# CITY OF ALBUQUERQUE

June 26, 2015

**Re: Winrock Section 2 Grading and Drainage Plan**  
**Engineer's Stamp Date 3-7-15**  
**Drainage file number (J19D058C)**

PROJECT TITLE WINROCK SECTION 2 AND 4			
WINROCK TOWN CENTER ALBUQUERQUE, NEW MEXICO			
PROJECT MANAGER SCOTT EDDINGS P.E.	JOB NO. 303689.01	DRAWN BY KLS	
SHEET TITLE PROPOSED STORM DRAIN

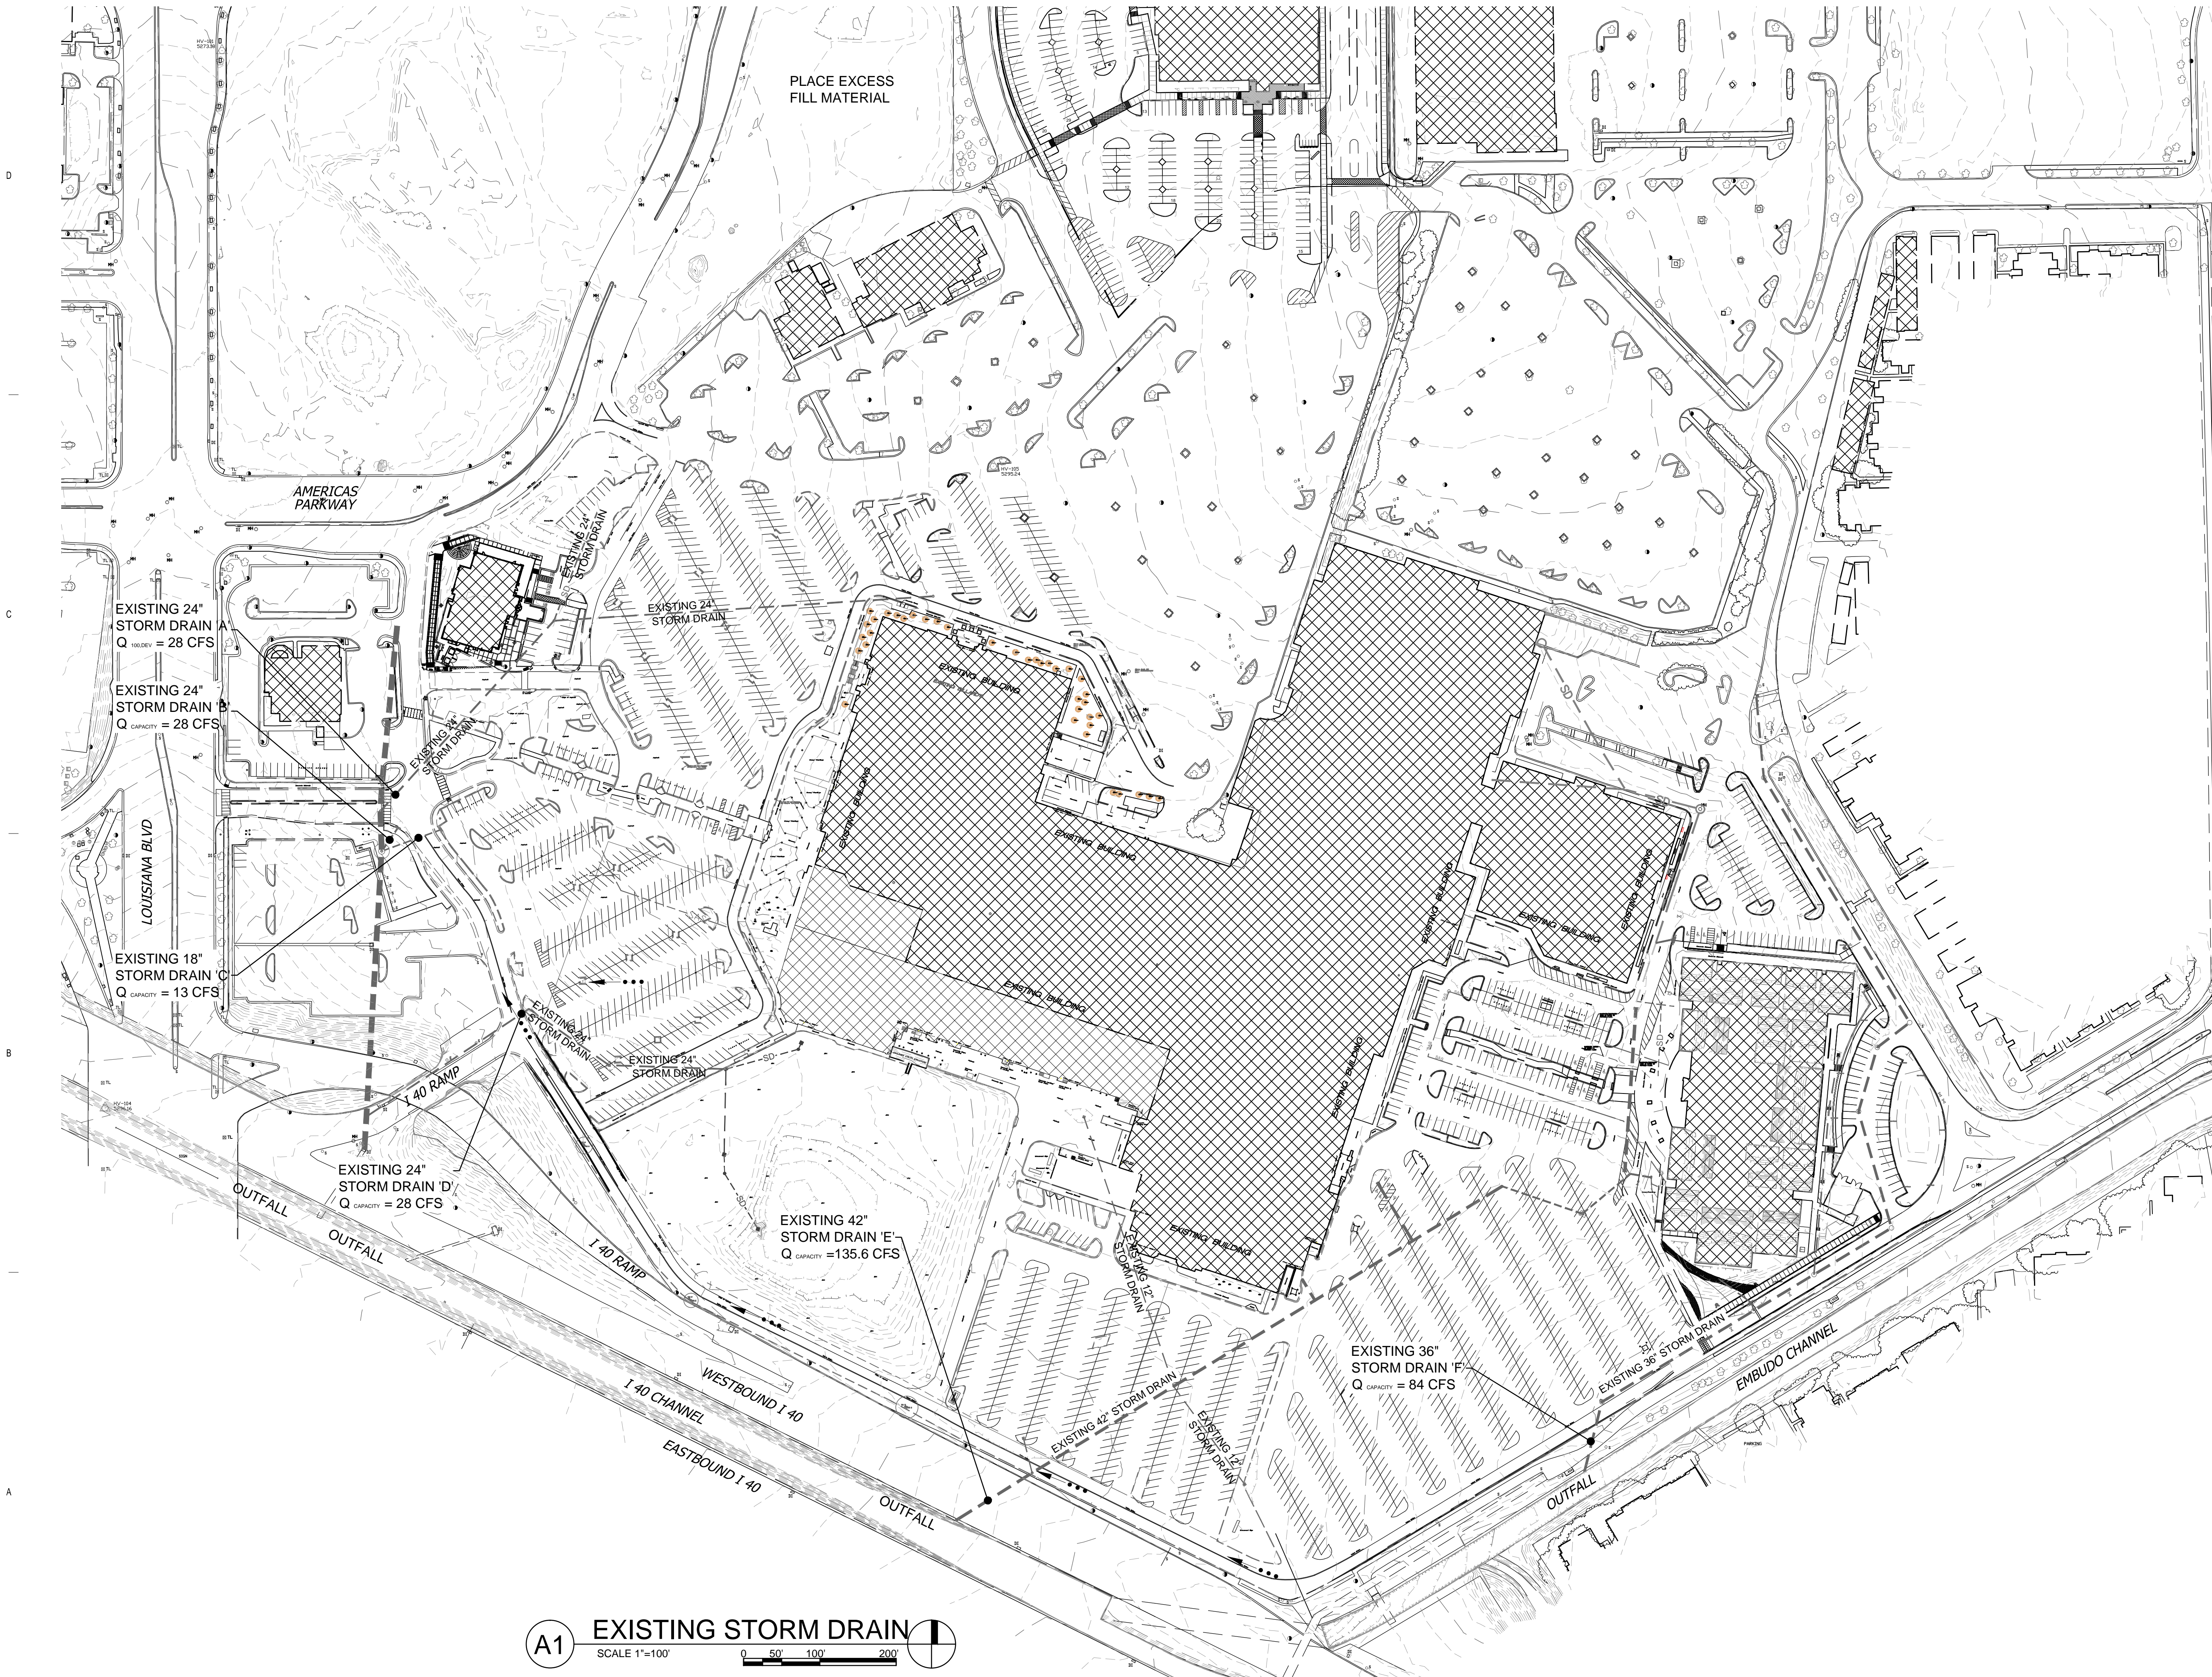
4. Storm drains 1, 2, 3 and 4 are not shown in the DMP.
5. Are storm drains to be public? If so, add a note they are to be built by the Work Order process.

6. Storm drain 7 is a 42" in the DMP, rather than a 36" as shown on the plan.
7. Per the DMP, roof flows from basin 500 are to drain to a future Tract L park/water feature. Water features are not a requirement and therefore may not occur. This site is directly connected to the I40 channel. The first flush from the rooftops should be accounted for in the interim (and maybe future) condition. This could be accomplished by redirecting roof flows to parking areas or draining them to an underground retention system that overflows into proposed storm drain 1.

8. The ABCWUA required a new easement in the latest platting action for Parcel A-1-A-1-A-1-A. In general, the ABCWUA does not want stormwater facilities in their easements. It appears storm drain 1 is in this new easement.

- a. Show all easements from the Parcel A-1-A-1-A-1-A plat on the grading plan.
  - b. If storm drain runs longitudinally through an existing easement, approval from the easement beneficiary is required.
